# Colston Budd Rogers& Kafes Pty Ltd

**RE: TRINITY GRAMMAR SCHOOL, SUMMER HILL**  
**RESPONSE TO MATTERS RAISED BY DPE AND PUBLIC**  
**SUBMISSIONS**

1. As requested, we have reviewed the traffic and parking matters raised by the Department of Planning and Environment (DPE) with regards to SSD-10371-Mod-1. We have also reviewed the traffic matters raised in submissions. Our responses to these matters are set out below.

Figure 3. Extract of Traffic Management Plan – Student Set Down and Pick Up (Colston Budd Rogers & Kafes 2022)

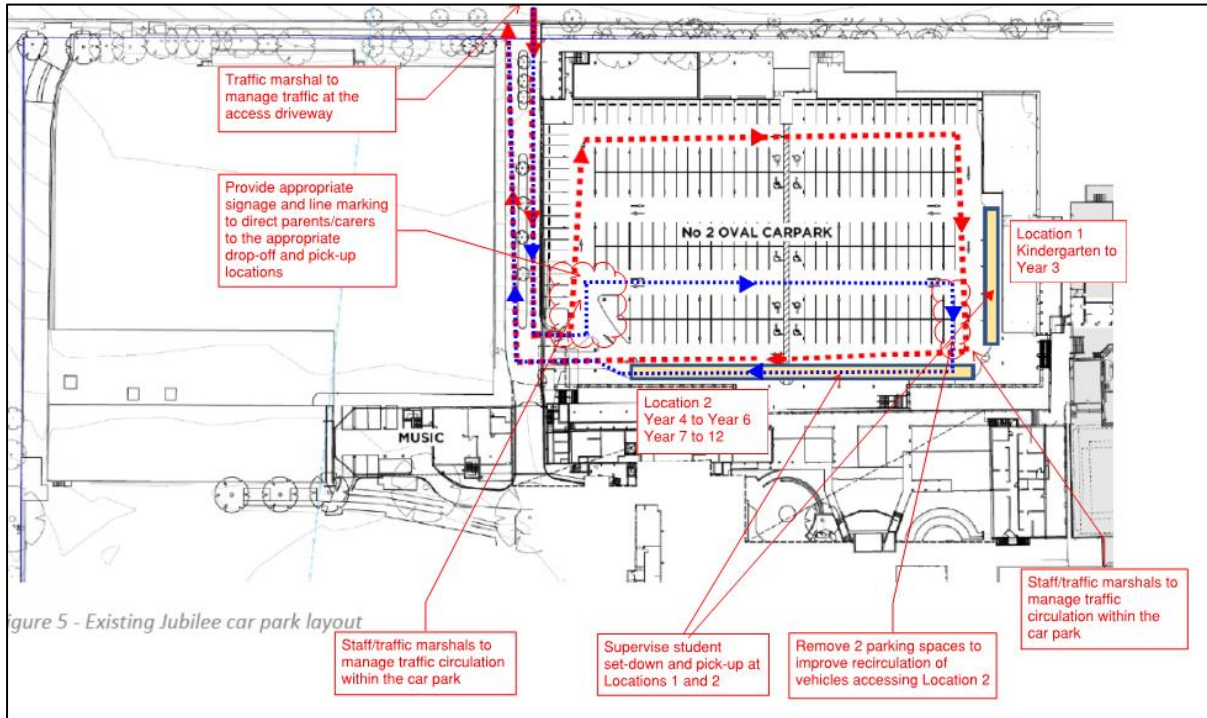
- a) *You are requested to identify the temporary drop-off/pick-up (DOPU) zone on Old Canterbury Road in a scaled site plan along with identification of existing driveway crossings, existing street signs including bus zones and no stopping zones. You are also requested to include information on the length of the*

*DOPU zone and the number of cars that can be accommodated in this zone during peak times.*

- b) You are requested to demonstrate how students would safely access the school site from the temporary DOPU zone on Old Canterbury Road*

3. Mod I proposes a temporary drop off zone in the morning on Old Canterbury Road during construction. No student pick up is proposed from this location. Figure I shows the location of the drop off zone (west of Prospect Road and west of the existing bus stop on Old Canterbury Road). It is approximately 80 metres long and has capacity to accommodate at least 10 cars.

4. The proposed temporary drop off zone is located within the northern kerbside lane of Old Canterbury Road, adjacent to Yeo Park. It will not impact on any Council/private land and will not affect any existing “No Stopping” zones, parking zones, driveways or clearways along Old Canterbury Road.

6. Figure I shows pedestrian access from the drop off zone to the school, via the use of existing footpaths. This path is along the northern side of Old Canterbury Road and the western side of Prospect Road.
